From: Andy Nixey
Sent: Thursday, 10 May 2018 12:12 PM
To: Andy Nixey
Subject: FW: Notice of Exhibition - Ivanhoe Estate Redevelopment (SSD 8707)

From: Jason Wall [mailto:jwall@ausgrid.com.au]
Sent: Thursday, 10 May 2018 11:52 AM
To: Andy Nixey <Andy.Nixey@planning.nsw.gov.au>
Cc: Grant Greene-Smith <ggreenes@ausgrid.com.au>; Tim Knight <tknight@ausgrid.com.au>; James Hart <JHart@ausgrid.com.au>; Alex Wang <Alex.Wang@planning.nsw.gov.au>
Subject: RE: Notice of Exhibition - Ivanhoe Estate Redevelopment (SSD 8707)

Ausgrid has reviewed the documents and notes that contact has been made with Ausgrid regarding options to connect the new development.

**Figure 7.1 – Existing Electricity Infrastructure**

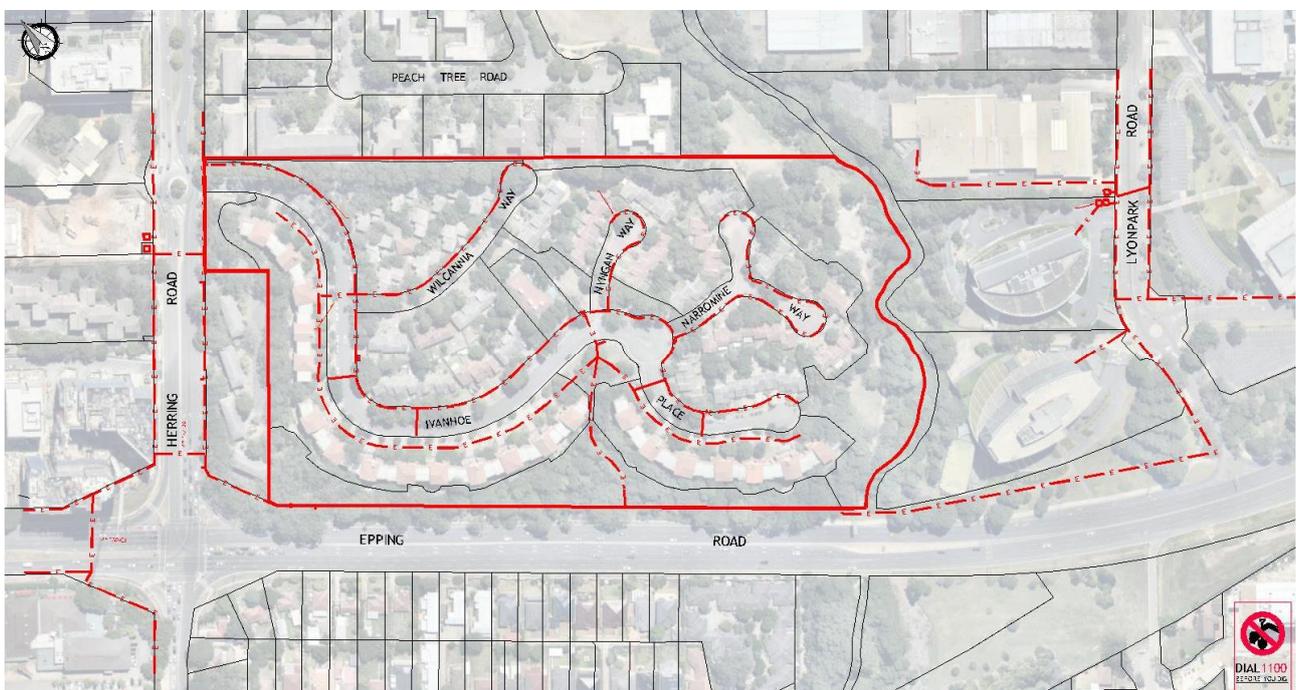
From a safety perspective, the proponent will also need to identify a methodology for removal of the existing Ausgrid assets due to the road realignment.
